2023/0063

1 Victory Gardens, Birdwell, Barnsley, S70 5FD

Erection of detached garage to front of dwelling

FRONT ELEVATION
Scale 1:100

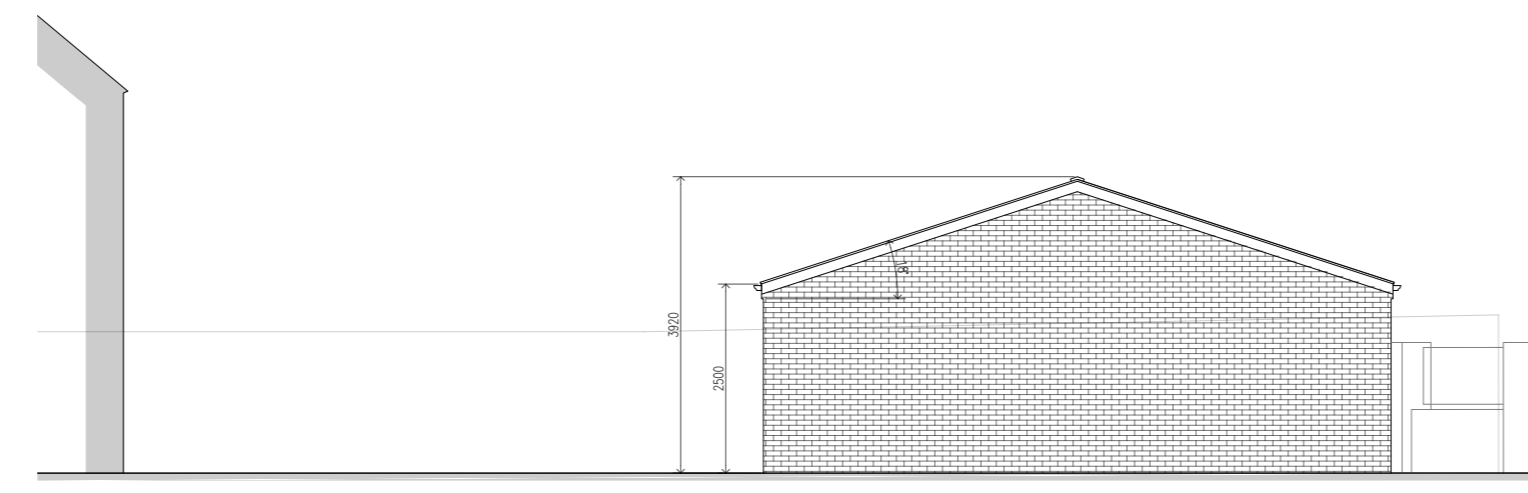
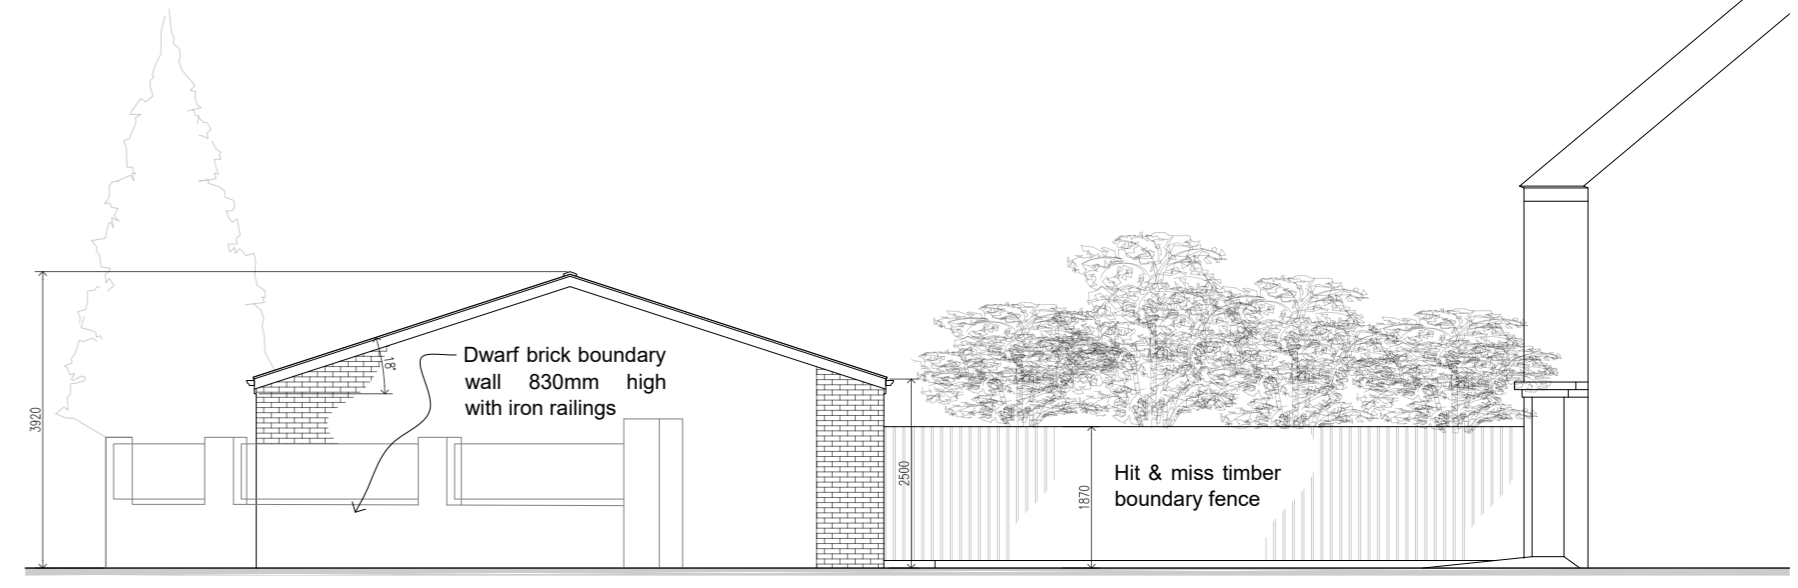
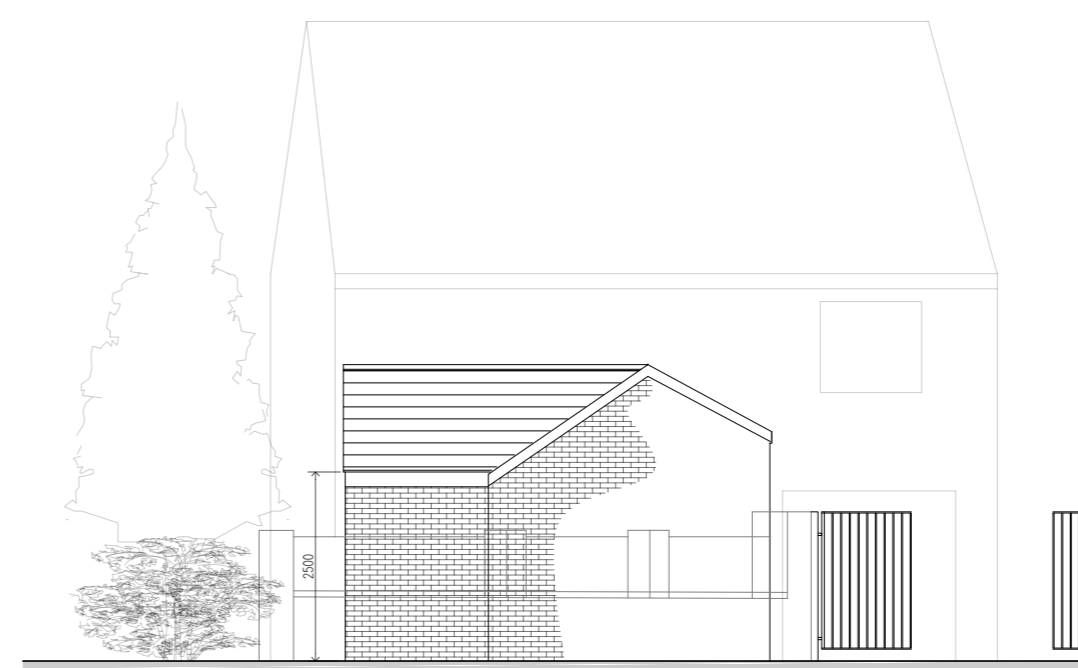
Original proposals showed a relatively large, detached garage with an approximate eaves and ridge height of 2.58 metres and 5.1 metres respectively. This would have resulted in the appearance of a two-storey structure that would have had a similar eaves height to that of the applicant dwelling, appearing particularly overbearing and not consistent with the character of the street scene.

Amended proposals which are being considered were received 07/03/2023 and show a pitched roof with a reduced eaves and ridge height of approximately 2.5 metres and 3.9 metres respectively. Due to the unconventional shape of the site and subsequently the form of the proposed garage, the proposed width of the garage would vary; at its narrowest point the proposed width would be approximately 1.9 metres and at its widest, 5.61 metres (both measured externally), allowing an entrance way of approximately 3.61 metres in width to be created. The proposed total length of the garage would be approximately 8.3 metres (measured externally).

The SPD states that *'Detached garages should be single storey structures and the eaves height should not normally exceed 2.5m from ground level and that in most cases it is not considered appropriate for detached garages to include dormer windows as a way of accommodating rooms in the roof space'*. In this instance, the proposed detached garage would be of a single storey and would utilise an eaves height of approximately 2.5 metres with no provisions to include dormer windows. It would also utilise a relatively restrained ridge height not too dissimilar from existing detached garages seen within the street scene.

PROPOSED GARAGE FLOOR PLAN
Scale 1:50

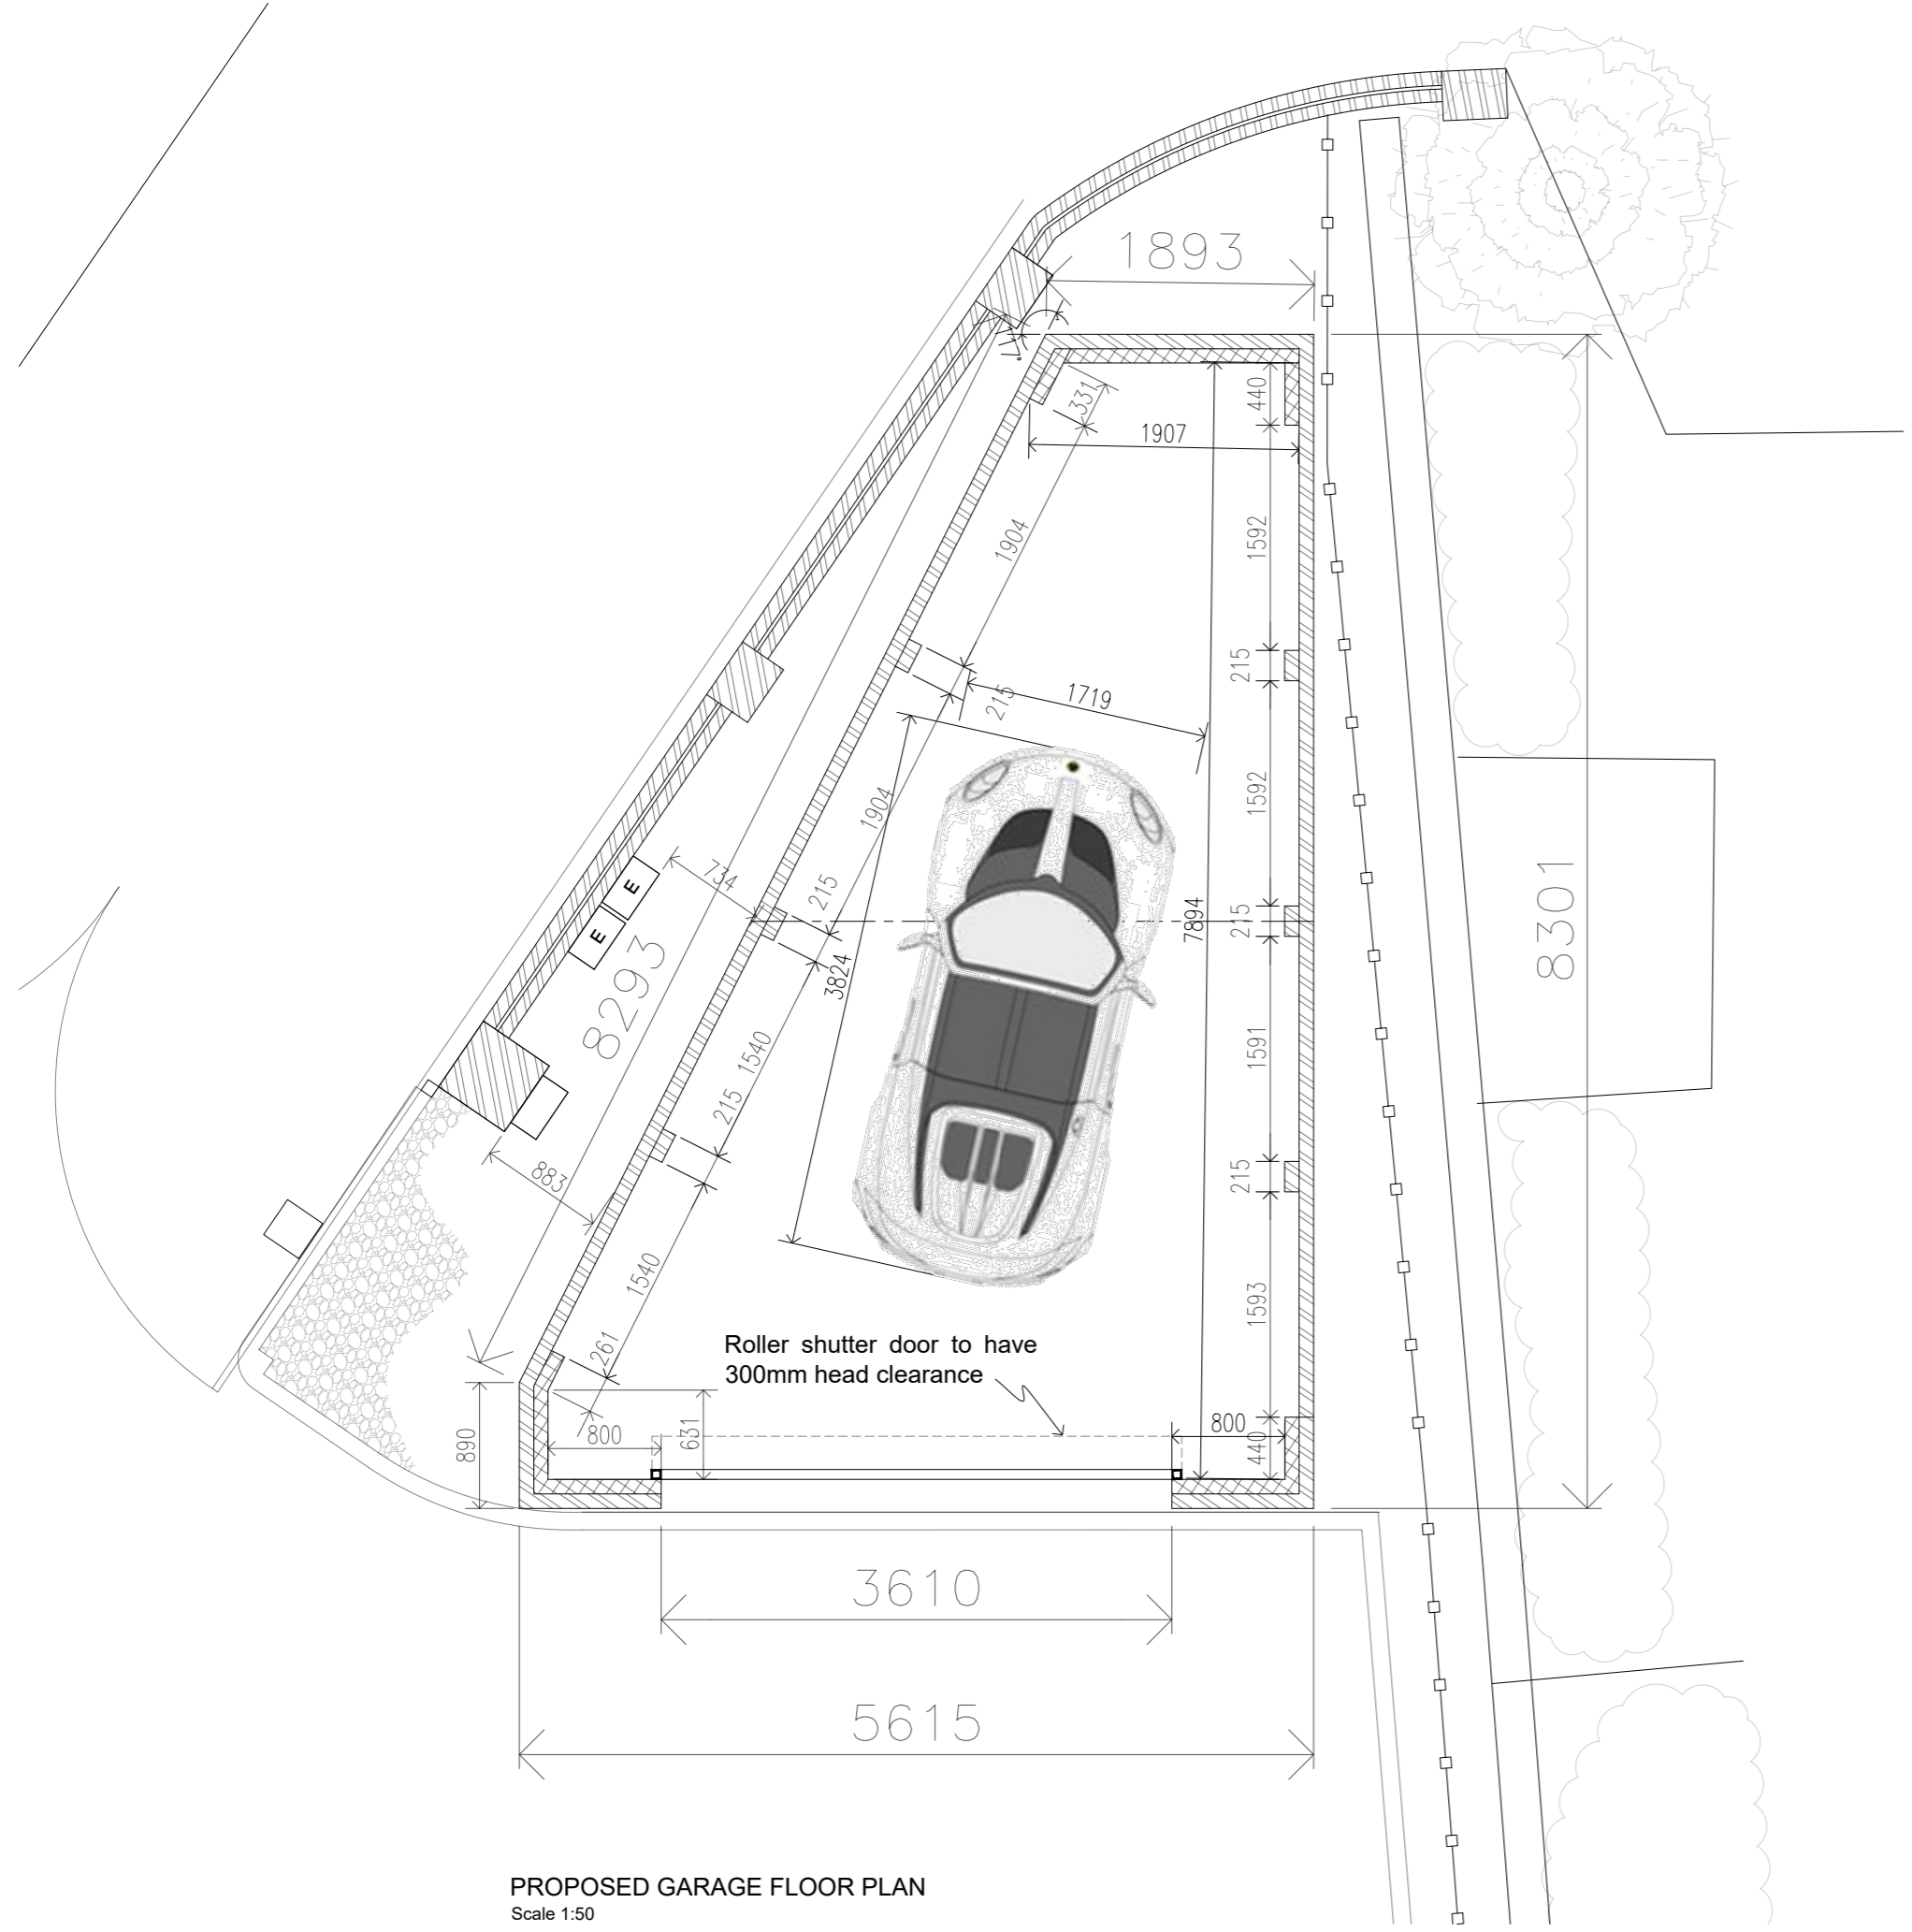
Internal measurements would also vary due to the unconventional form of the proposed garage, with the length and widths measuring at approximately 7.9 metres, 5.3 metres (widest), and 1.9 metres (narrowest).

SITE PLAN
Scale 1:500

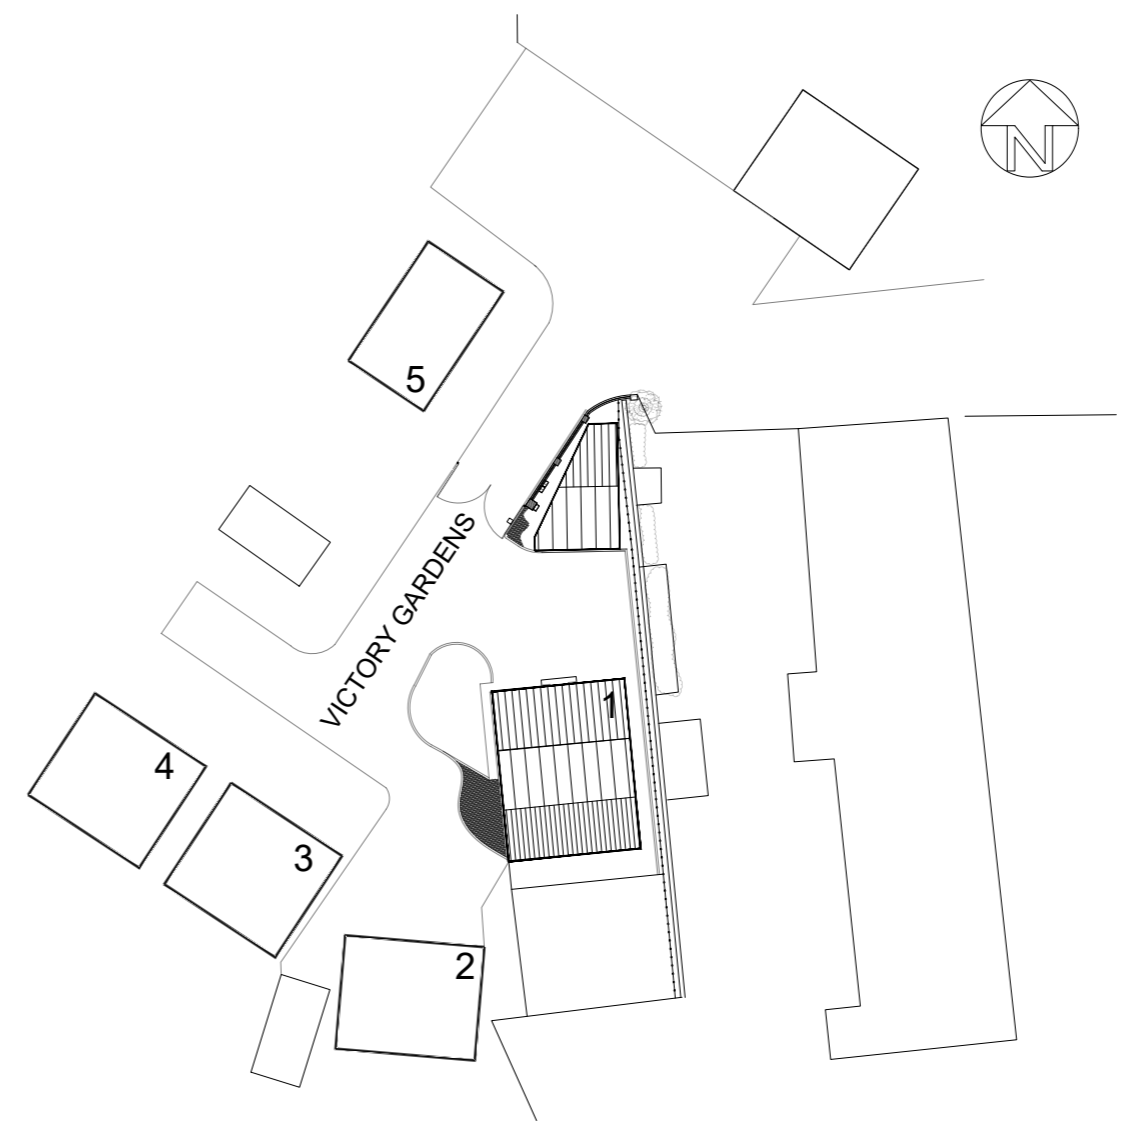
The SPD states that *'detached garages should relate sympathetically to the main dwelling in style, proportions, and external finishes; in most cases, it will not be appropriate for a garage to be sited between the house and the road.'* In this instance, the proposed detached garage would be forward of the applicant dwelling and therefore, considered between the house and the road; however, the location of the garage would be setback and relatively tucked away from the primary highway of Sheffield Road.

The location of the proposed detached garage would be sited forward of the applicant dwelling in an area underutilised at present that is setback and relatively tucked away from the main highway (Sheffield Road). Therefore, the proposed erection of a detached garage would not result in any loss of existing off-street parking provision and is unlikely to increase levels of obscurity or distraction that would be to the detriment of highways safety. As such, the proposals would be considered acceptable and in compliance with Local plan Policy T4: New Development and Transport Safety.
